RIBBLE VALLEY BOROUGH COUNCIL

APPEAL STATEMENT

Planning Inspectorate Reference:	APP/T2350/W/22/3304870
LPA Application Reference:	3/2022/0436

Prior notification application for the proposed conversion/redevelopment of two agricultural buildings into two dwellings

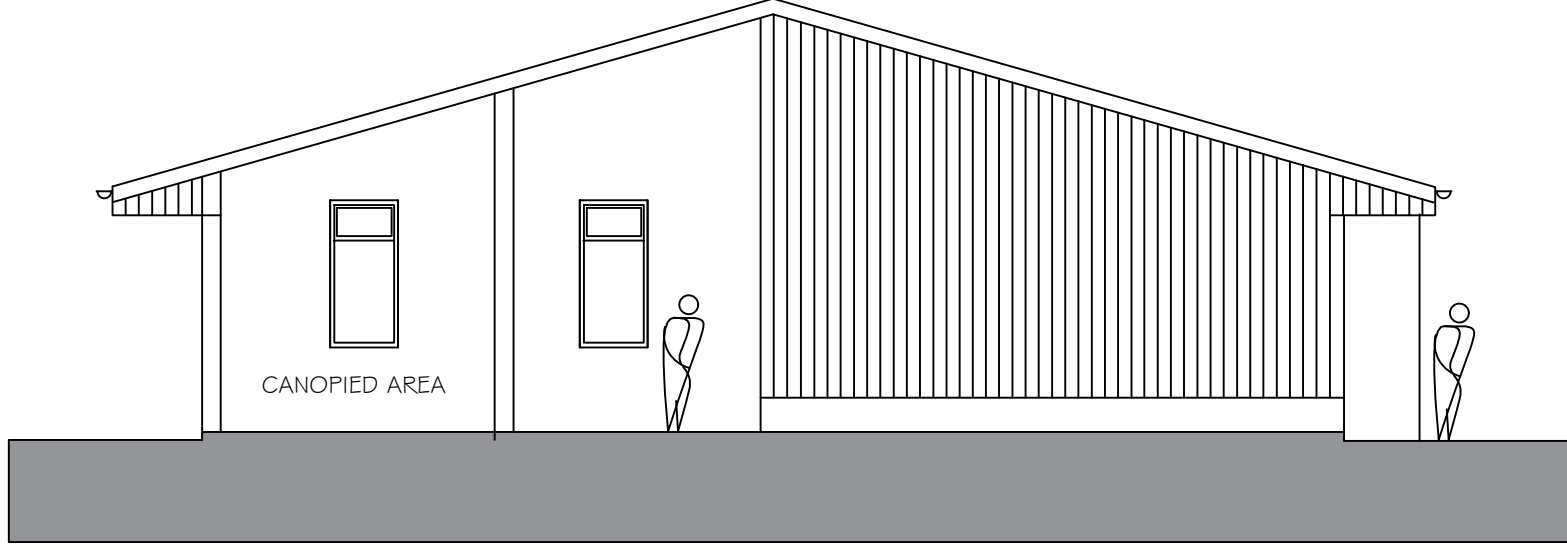
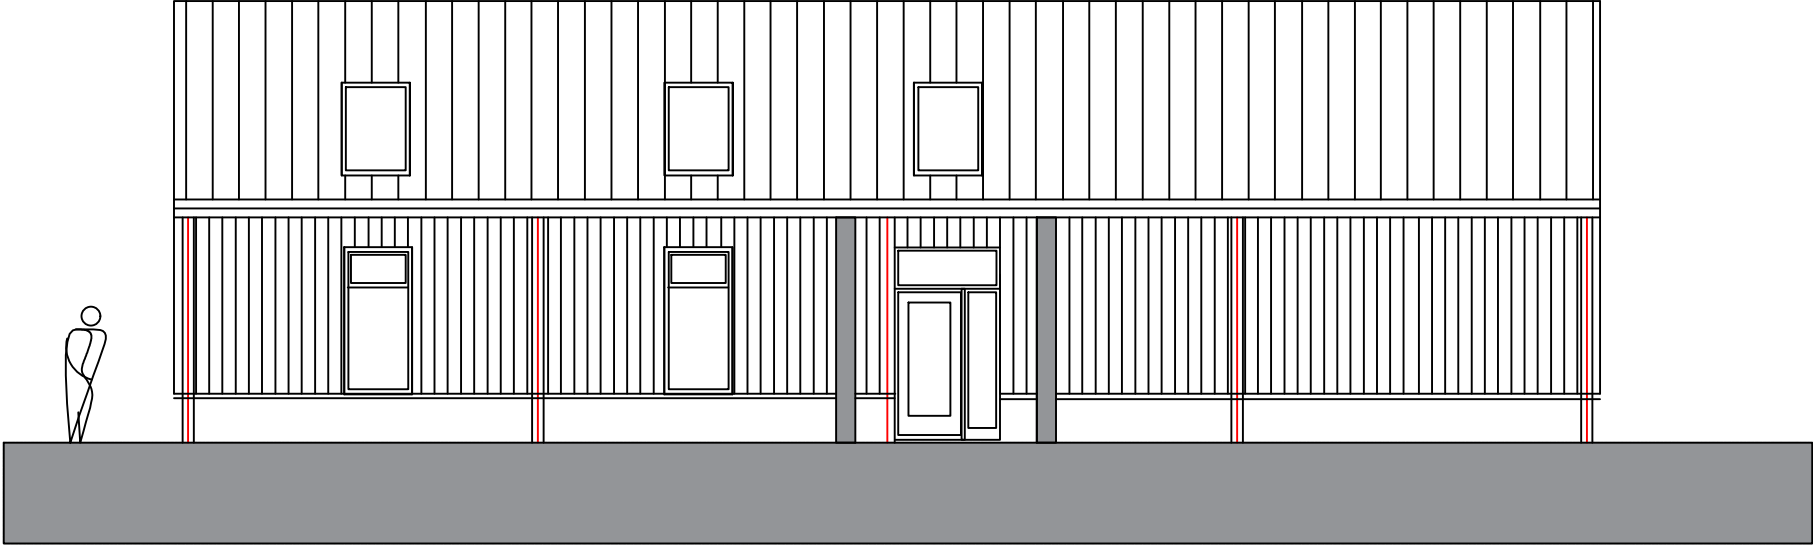
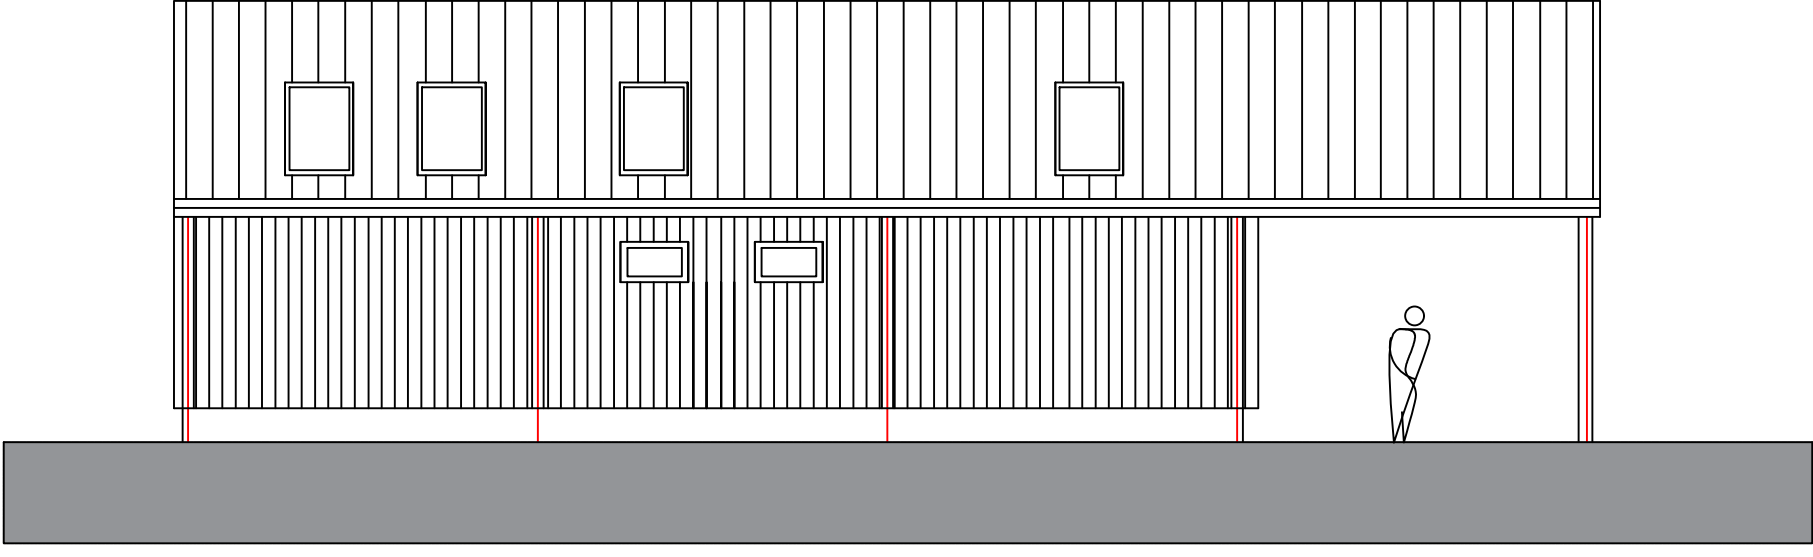
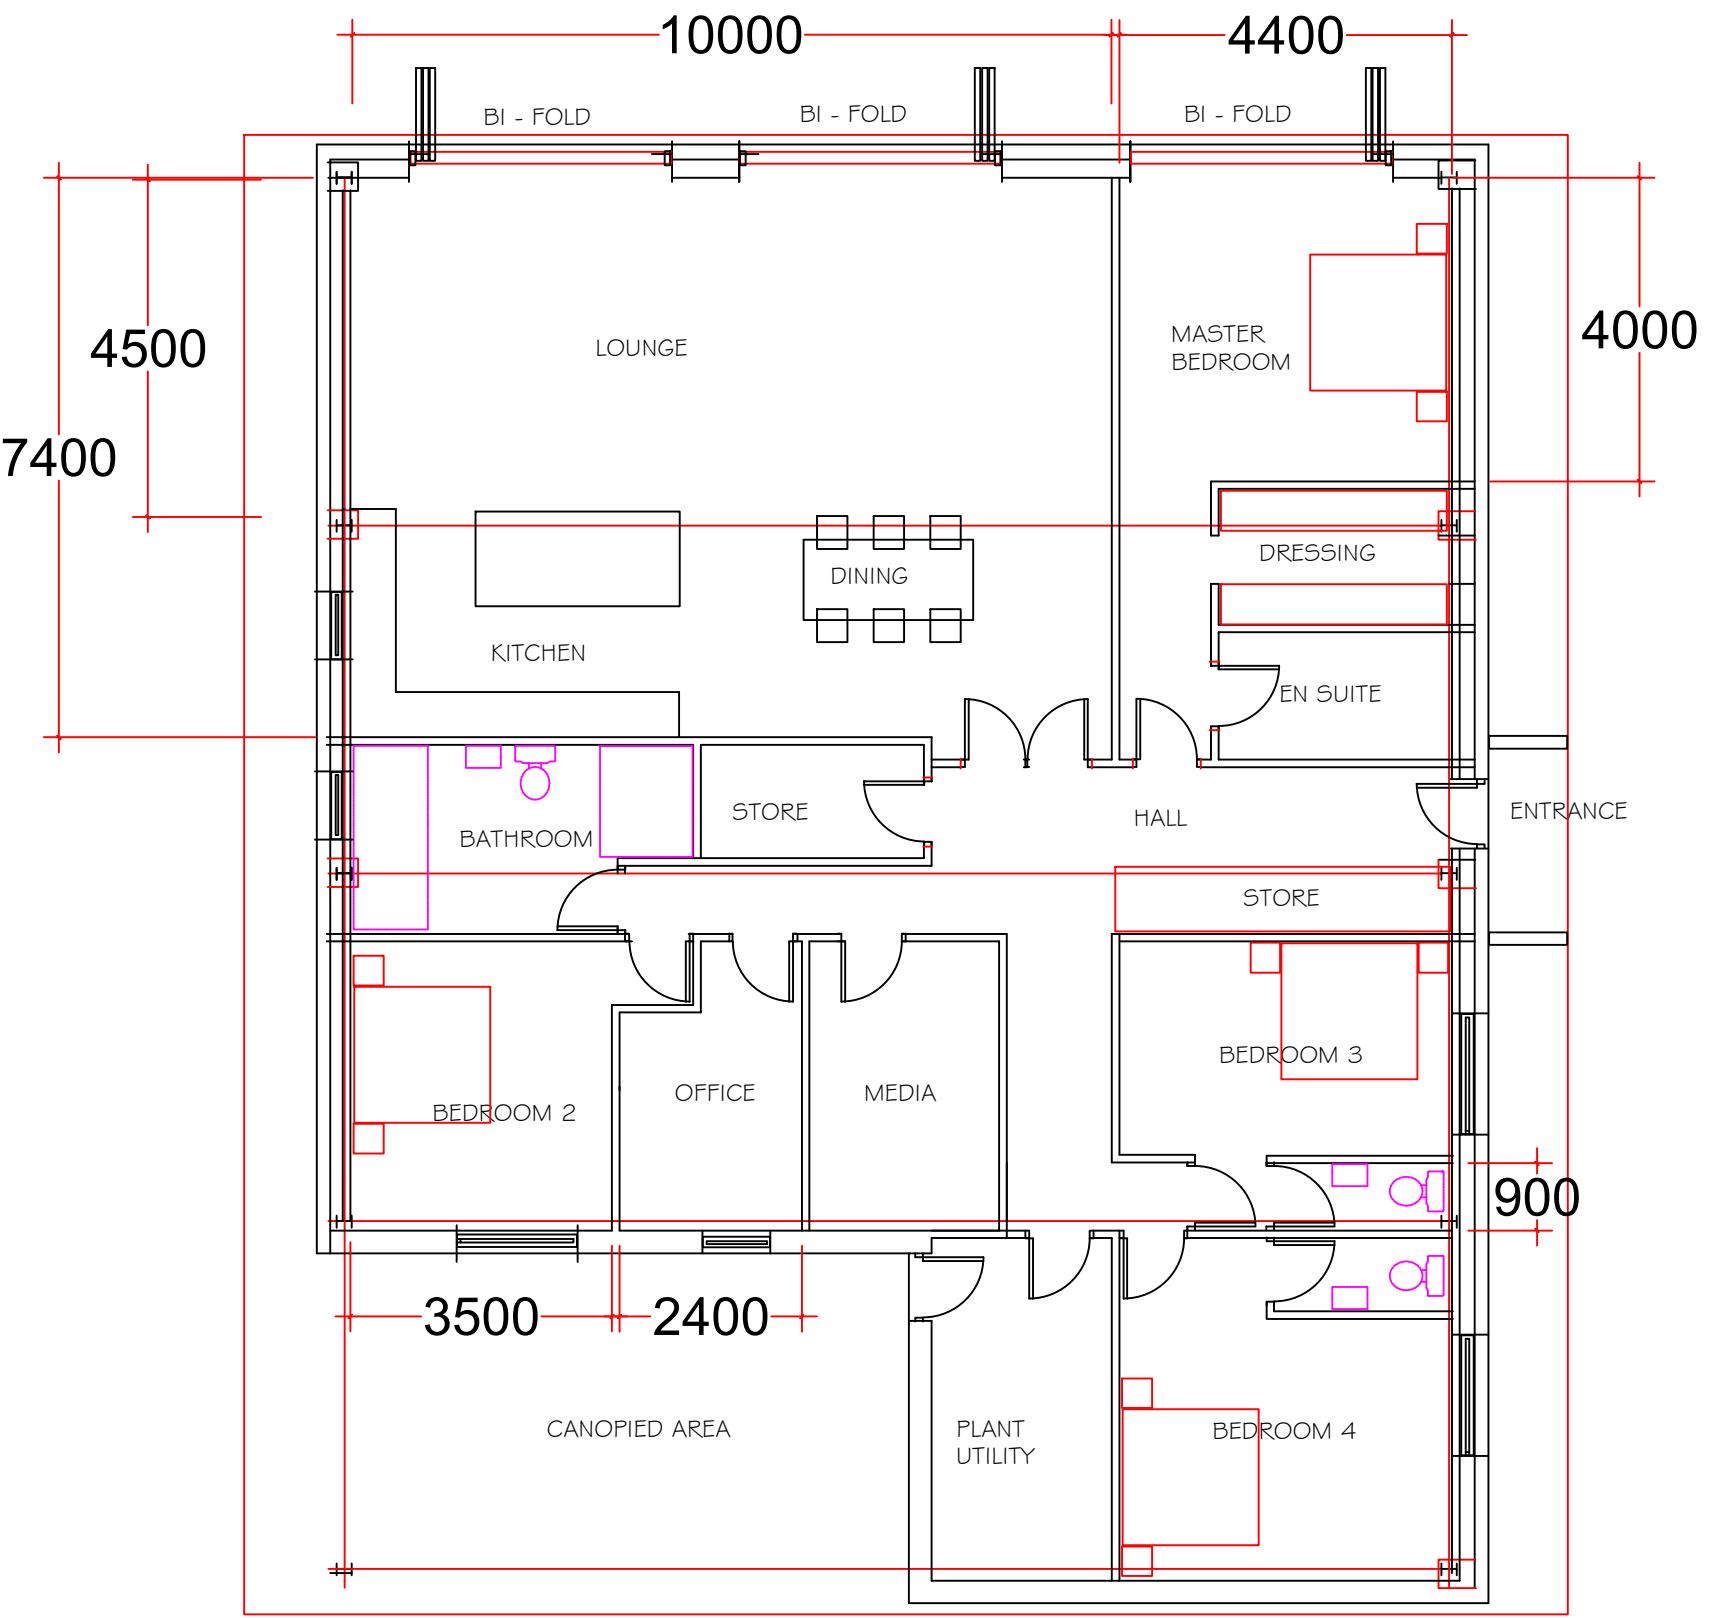
- 7.4 Taking into account the changes in design and materials with the introduction of numerous large, glazed elements and rooflights this scheme has the appearance of 'retro-fitting' a residential use into buildings not designed for such a use.

- 7.6 The existing modern steel framed buildings have a functional agricultural purpose and do not represent high quality design. Whilst a modern design is not necessarily unacceptable in this case the design would create an incongruous feature in this rural location. Therefore, the proposed development is not acceptable in terms of design and materials in this location.

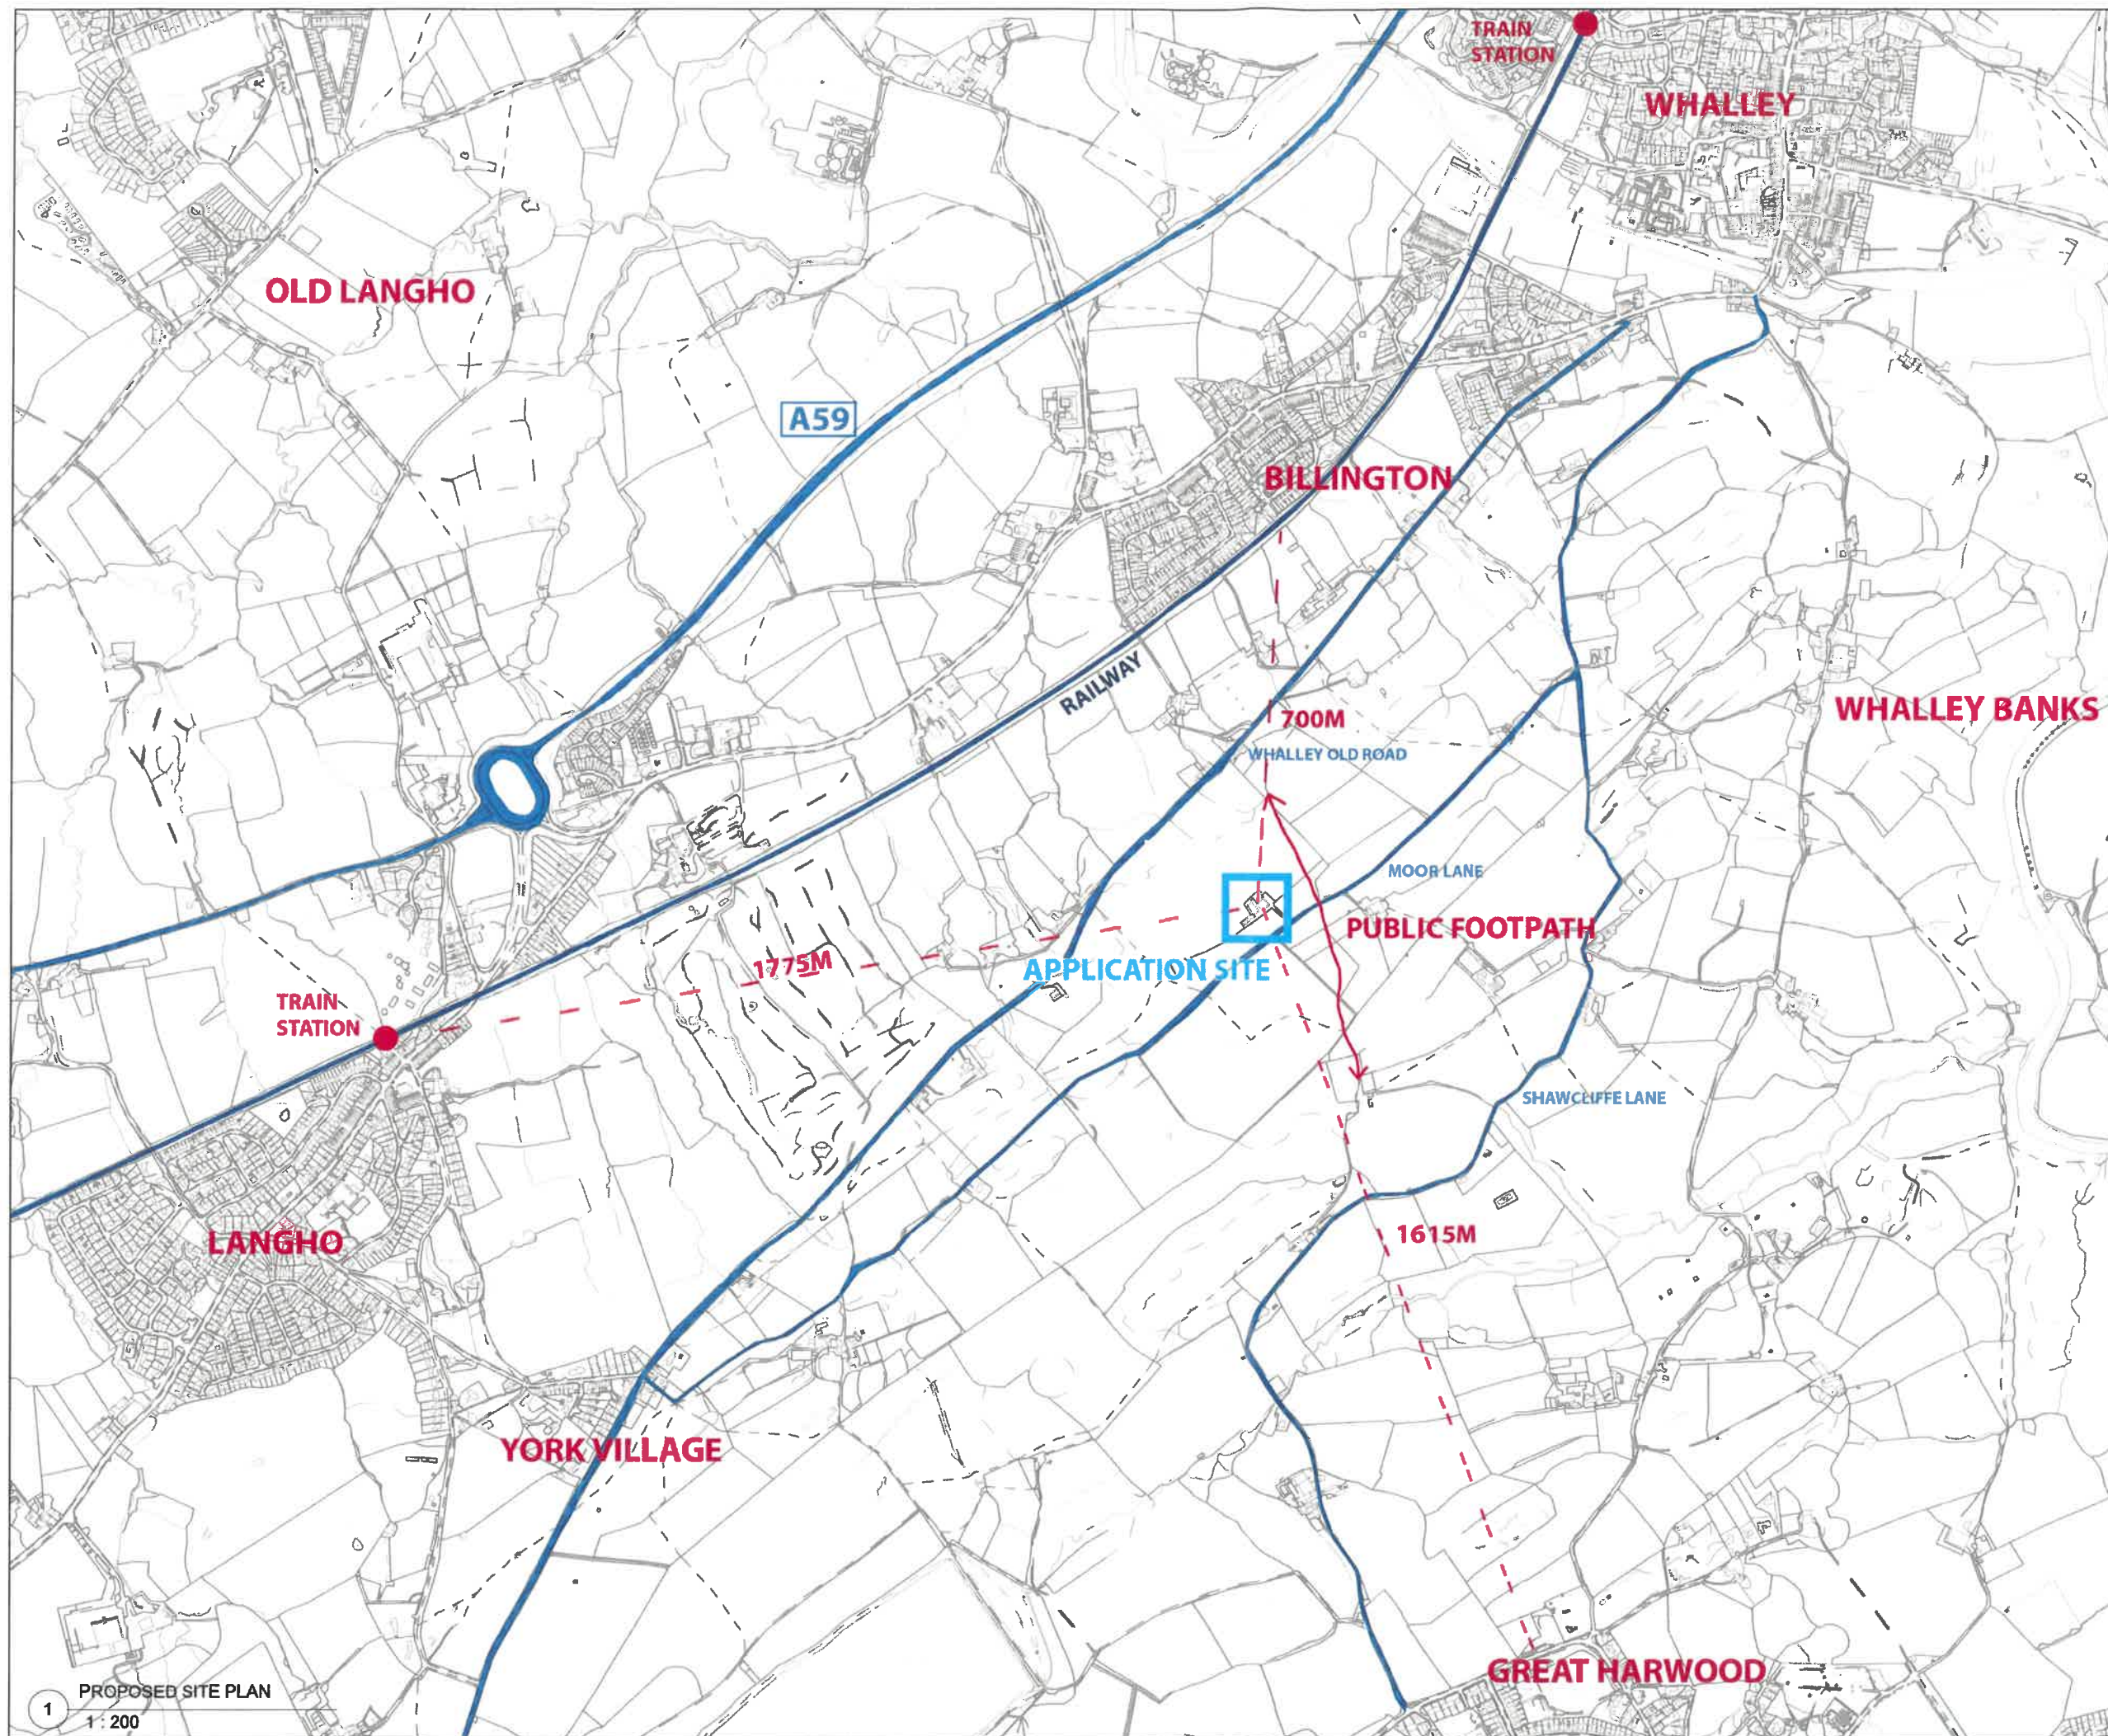
- 8.2 The submitted site context plan clearly shows the site in relation to existing built form and supports the view of the LPA that the site is isolated in terms of its location.
